PLANNING CONSULTATION RESPONSE

Application No	2026/0016
Proposal	Two and single storey rear extensions to dwelling.
Address	The Beeches, Halifax Road, Thurgoland, Sheffield, S35 7AL.
Date of Consultation Reply	20/02/2026
Consultee	Edward Jowett (Tree Officer)

1 Proposed Site Plan
 1 : 100 @ A0

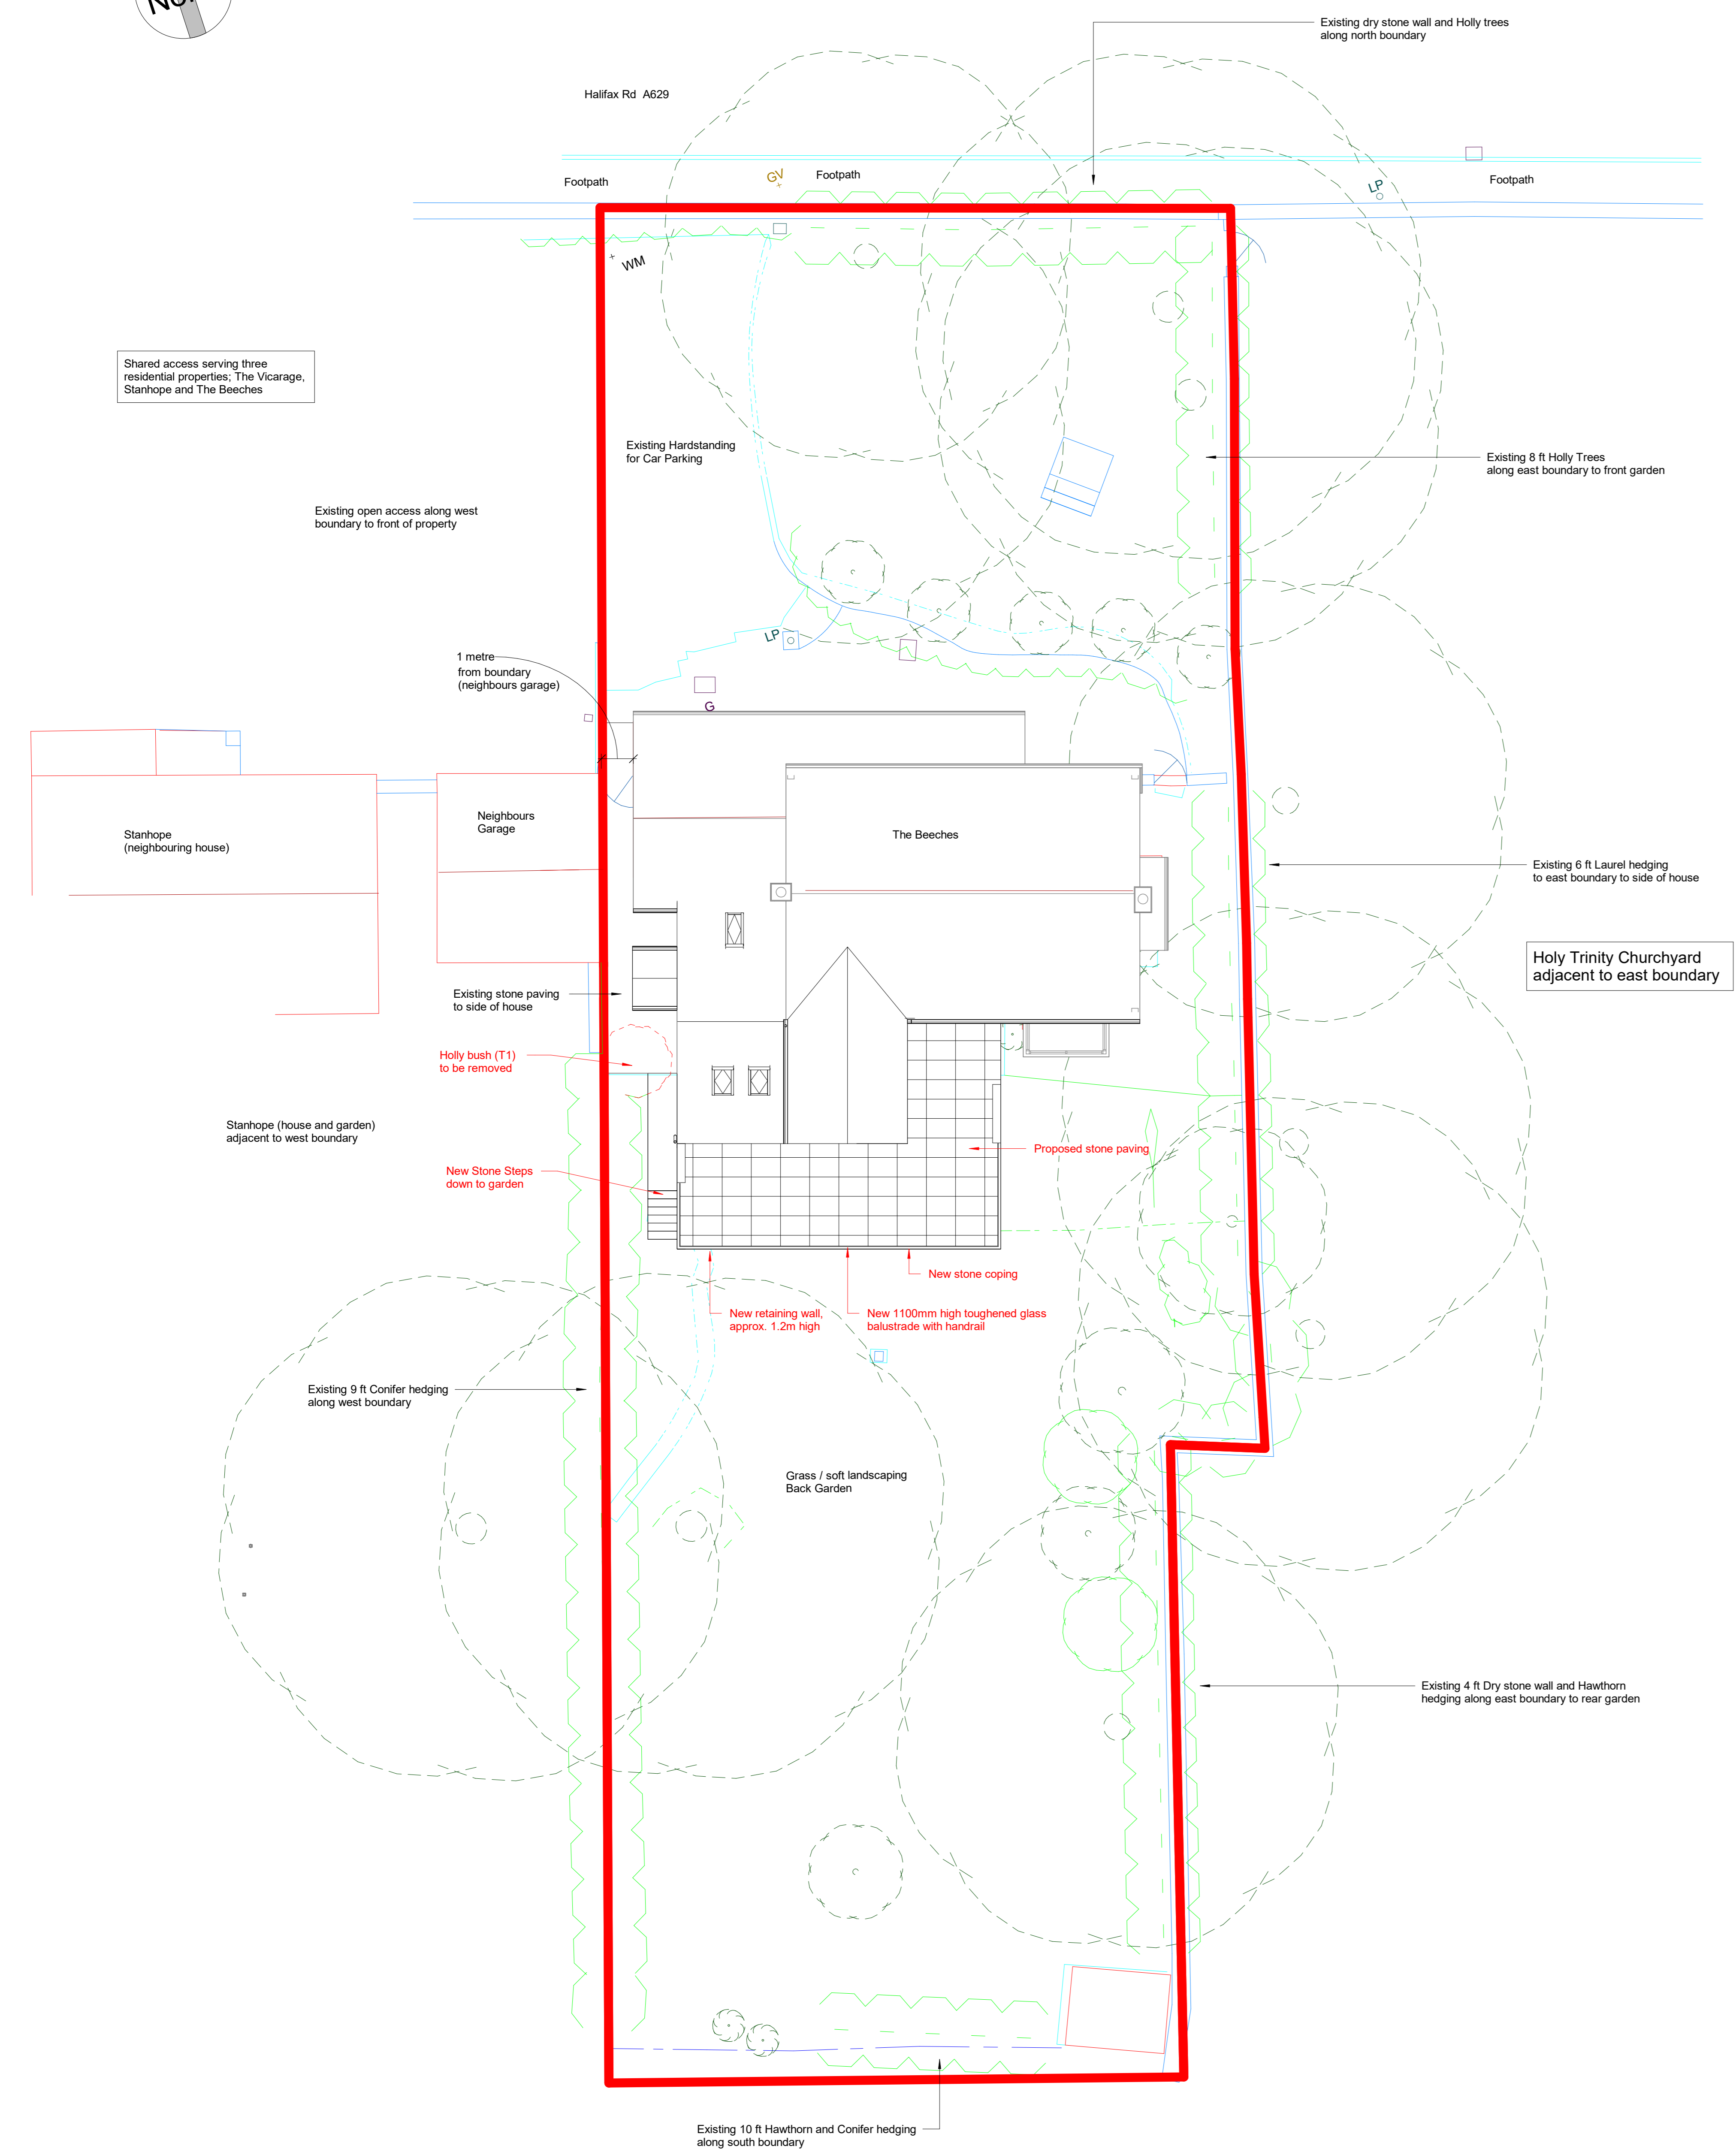
The proposed extension will be located close to the edge of the rooting areas of the TPO trees T1 and T8 (off site) and will require the removal of part of H1 and the small trees T2 and T3. The removals required will have a negligible impact as they are not significant specimens or prominent in the immediate vicinity.

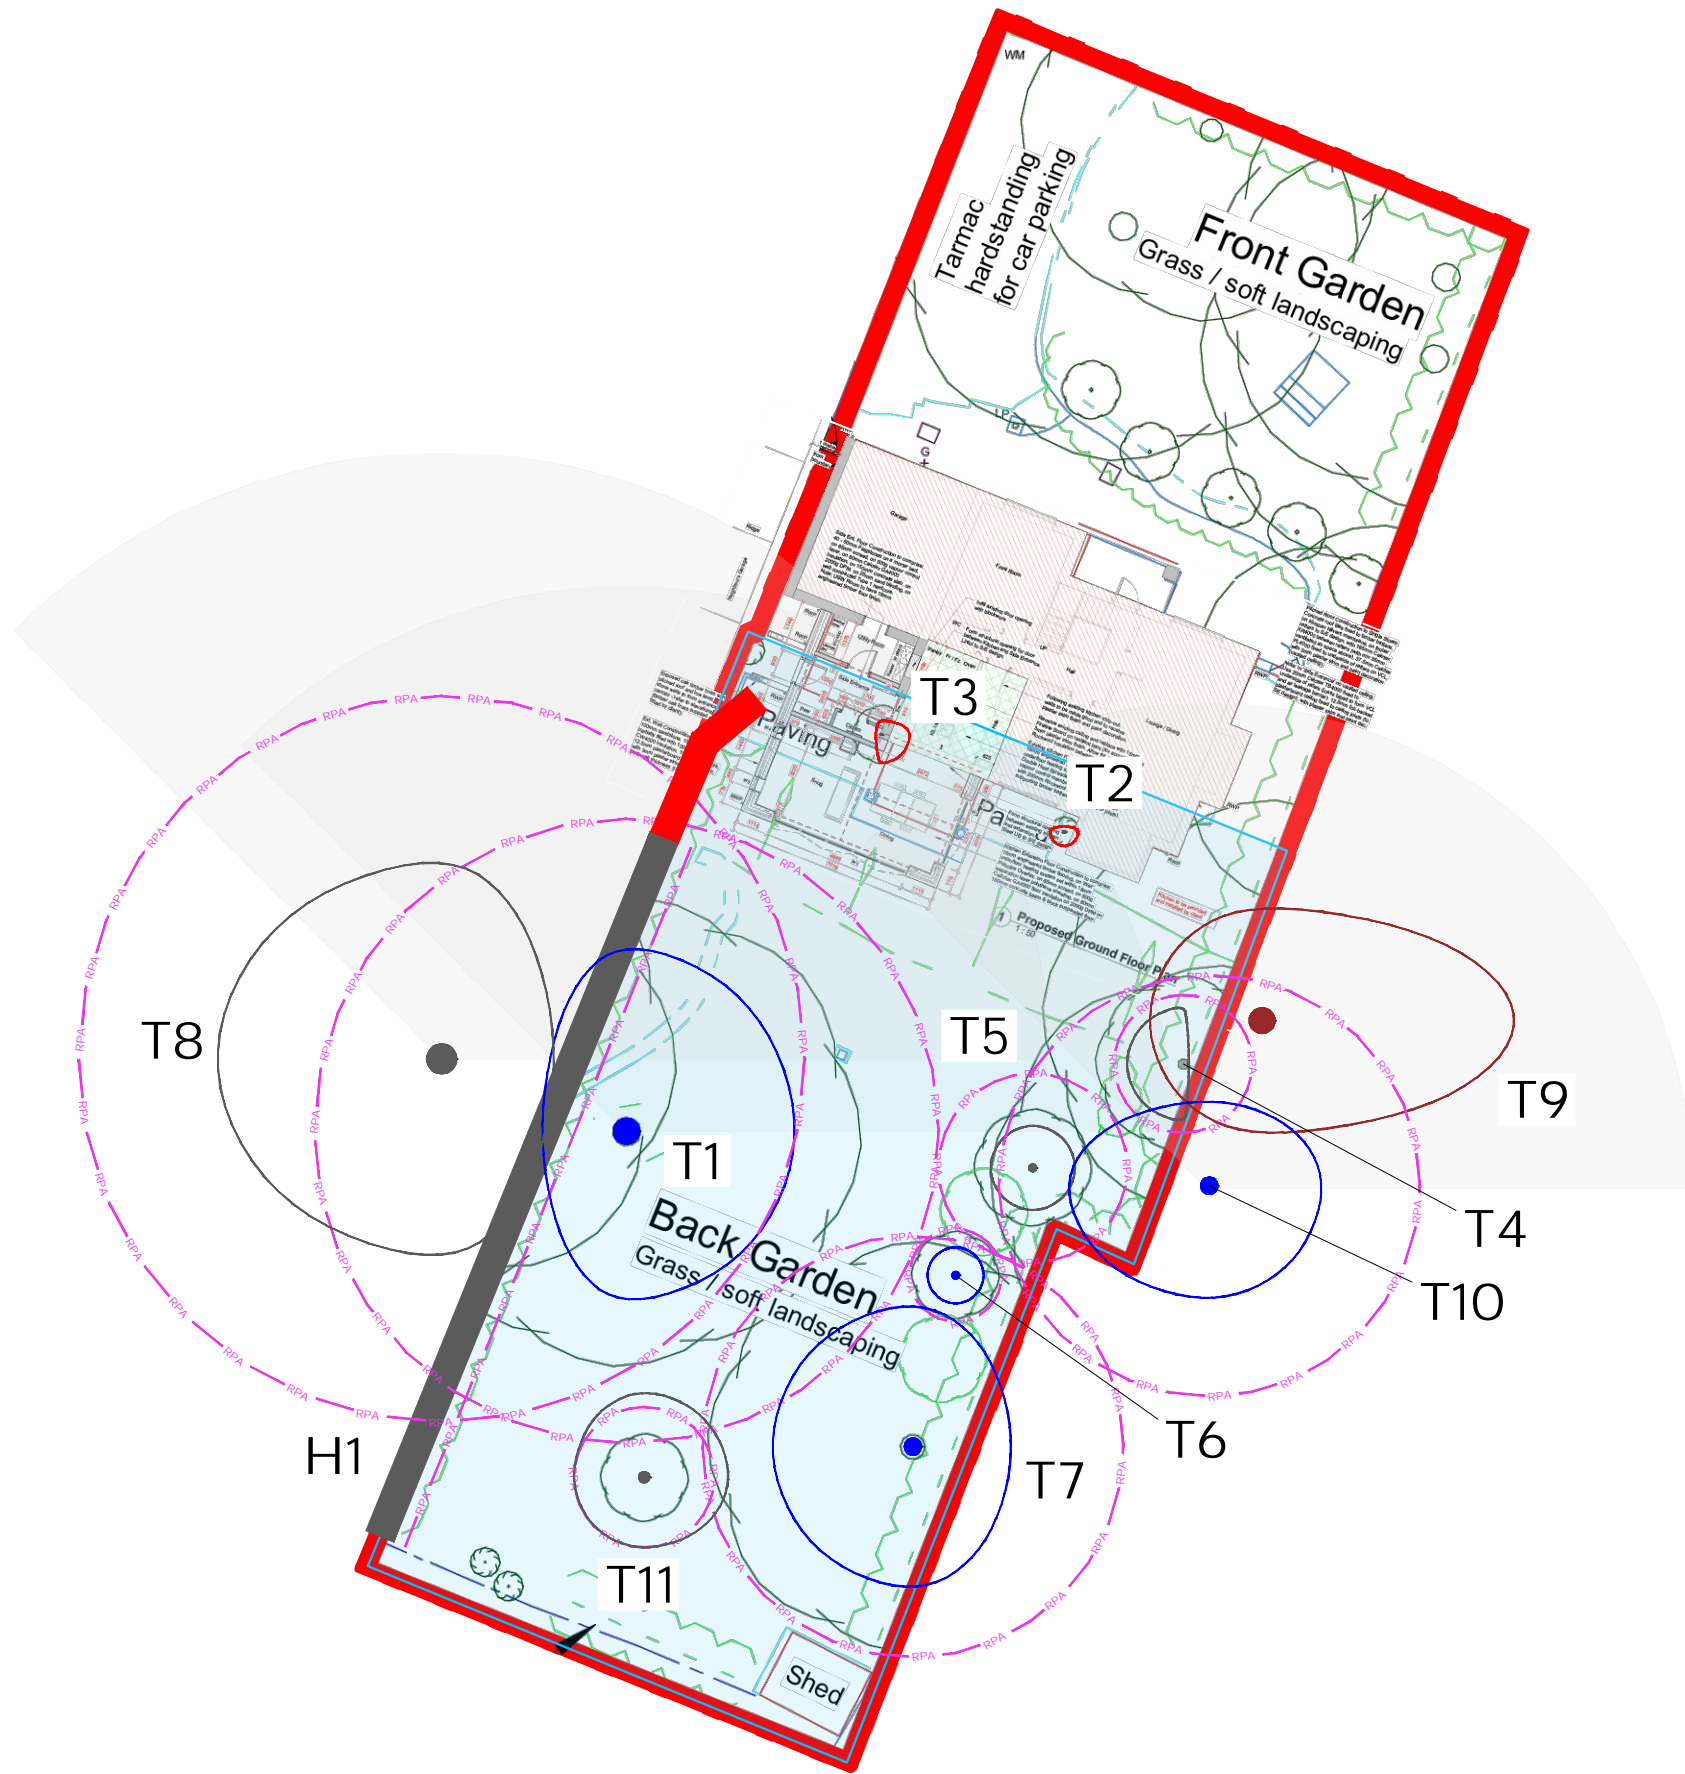
No direct works will be undertaken in the rooting areas of T1 and T8 although I understand some minor excavations may be required to facilitate the scheme but it is proposed to do these by hand under the supervision of the project arboriculturist. Therefore any impacts as a result of this will be minimal.

The full details of the protection measures for the trees will need to be dealt with as part of an arboricultural method statement including protective fencing/barriers as well as the details of on site supervision and methodologies which will be employed such as those mentioned above.

There is no objection to this proposal from an arboricultural perspective subject to the arboricultural method statement being conditioned to be provided pre-commencement.
